19 May 2021

**Loreto Normanhurst Concept Plan and Stage 1 Works – SSDA 8996  
Response to Submission**

**Figure 1: ELC Original Parking Strategy**

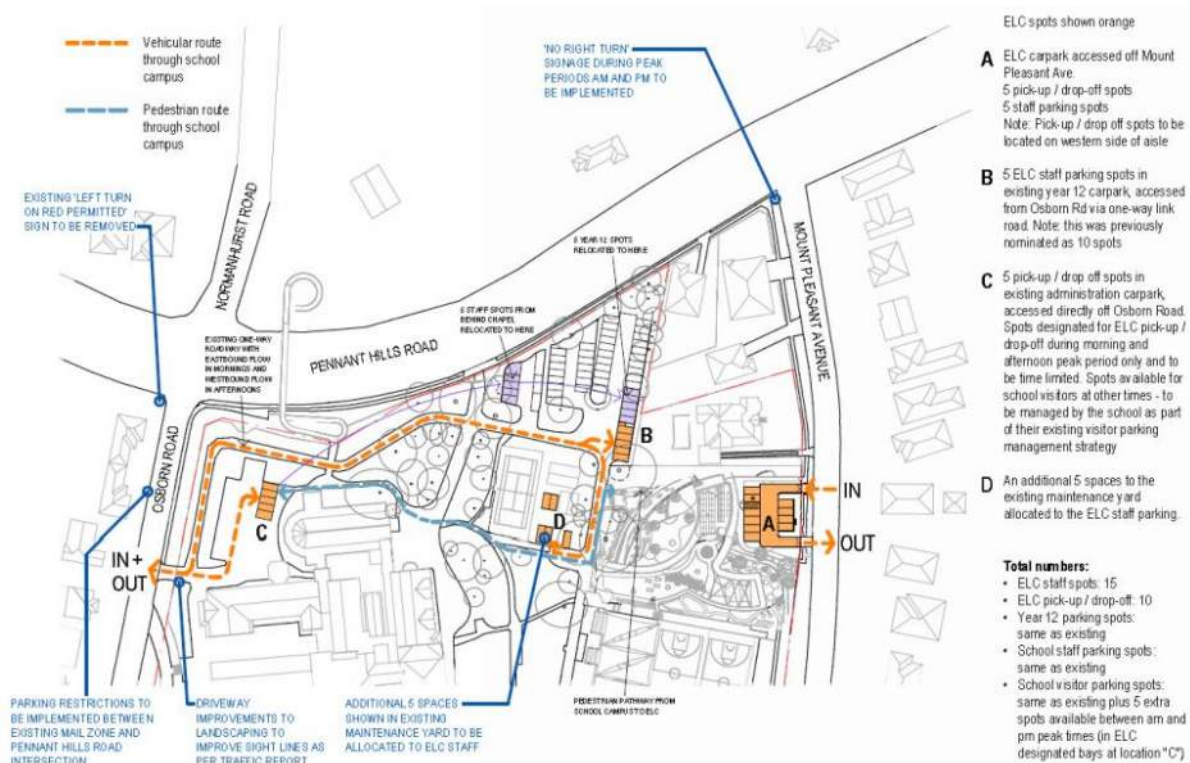
Please confirm the location of the 15 car parking spaces to be dedicated for Early Learning Centre use.

The 15 spaces required for the Early Learning Centre development application will be located within the spaces shown in Figure 1 in the Transport Response to Submission (RtS) Report, once the P1A carpark and through site link is constructed, the parking spaces that will be impacted by the works (at location 'B' and 'D' in figure 1 of the Traffic RtS Report) will be located within the P1A car park. These spaces will be clearly line marked as well as indicated to staff as part of the staff allocation discussed in Section 6.2.1 of the Operational Traffic Management Plan. See **Figure 5** below and **Appendix A** for further details.
